Ribble Valley Borough Council
Council Offices
Church Walk
Clitheroe
Lancashire
BB7 2RA

Phone: 0300 123 6780
Email: phillip.topping@lancashire.gov.uk
Your ref: 3/2026/0160
Our ref: 3/2026/0160/HDC/PT
Date: 3rd June 2026

Location: 3 Poplar Way Barrow Clitheroe BB7 9ZN
Proposal: Proposed single storey side and rear extension incorporating a garage conversion.
Grid Ref: 373486,438114

X 3 POPLAR WAY - SITE PLAN 1/1250

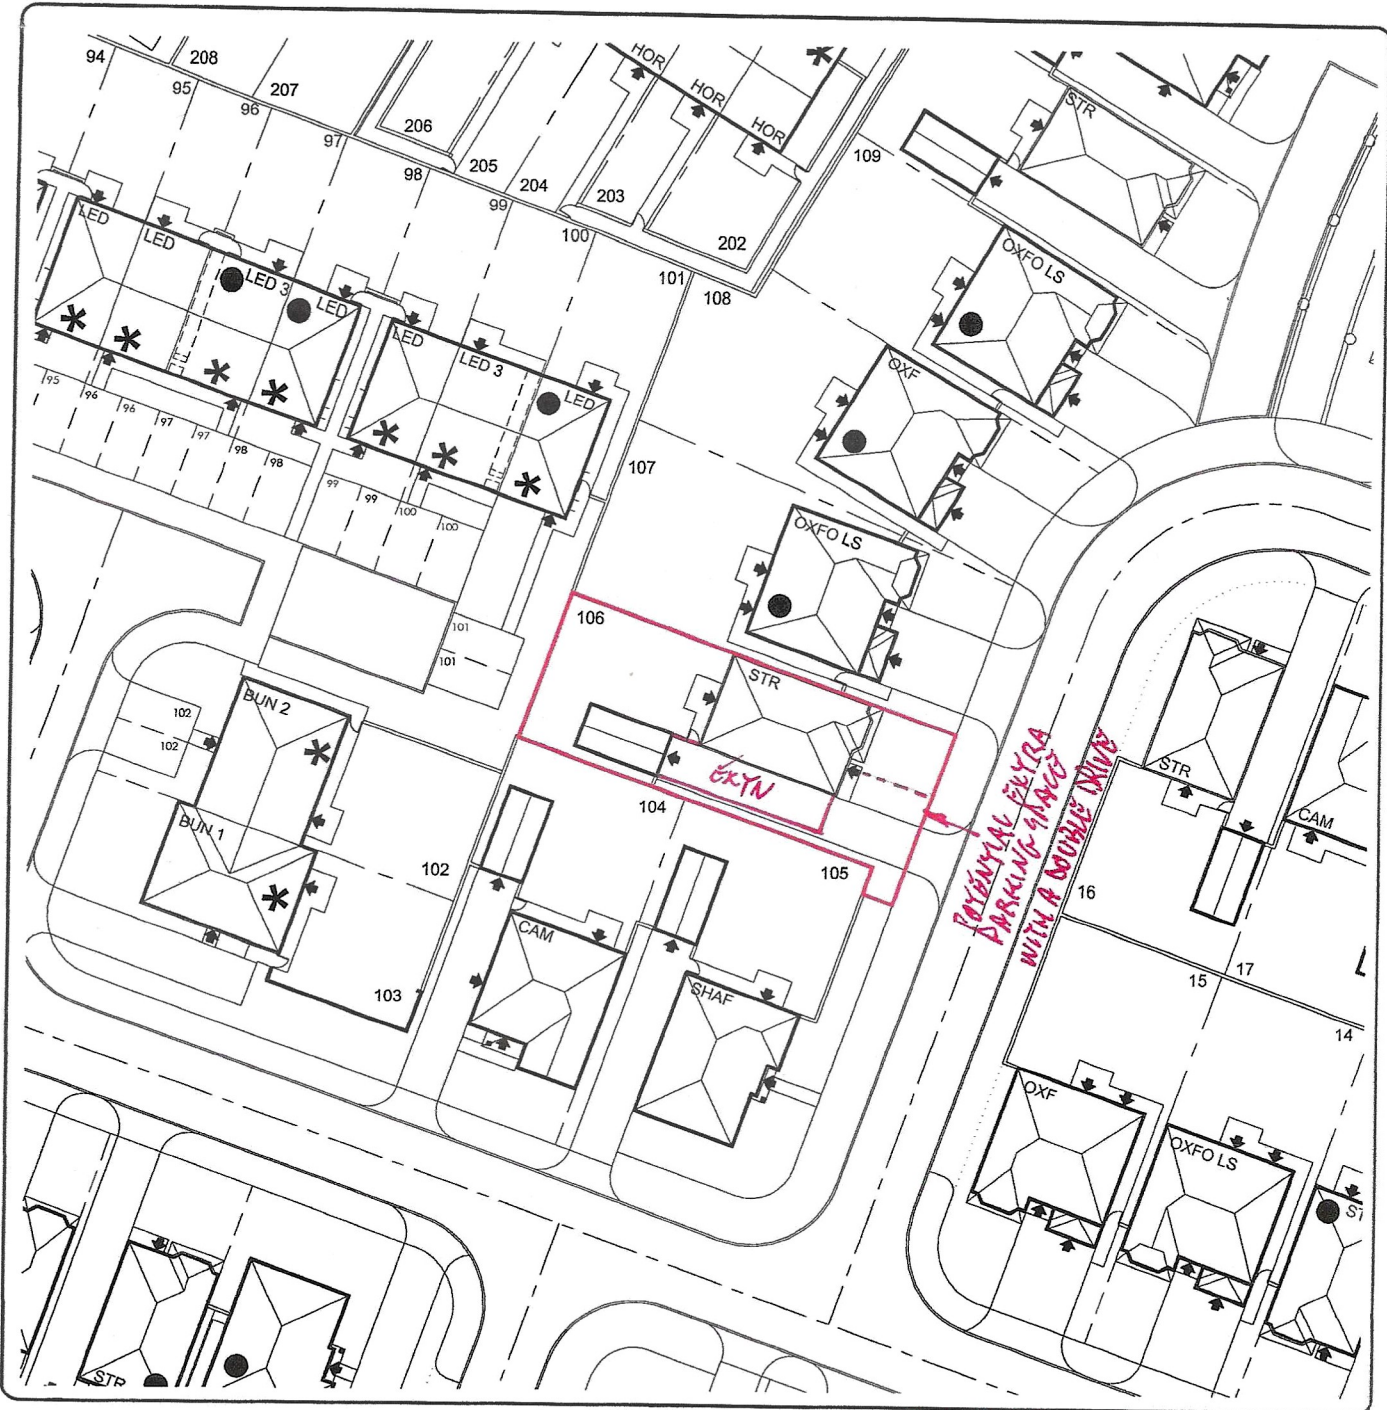
Although the applicant has stated in the application form that they intend to enlarge the existing parking to mitigate the loss of the use of the existing garage and available spaces. We will require a revised drawing to be resubmitted showing the parking arrangements being implemented in accordance with Ribble Valleys parking standards showing three available spaces.

Please can the applicant be made aware that the estate road (Poplar Way) is currently not adopted and they will need permission from the landowner to make any alterations to the parking provisions that will affect the layout of the highway.
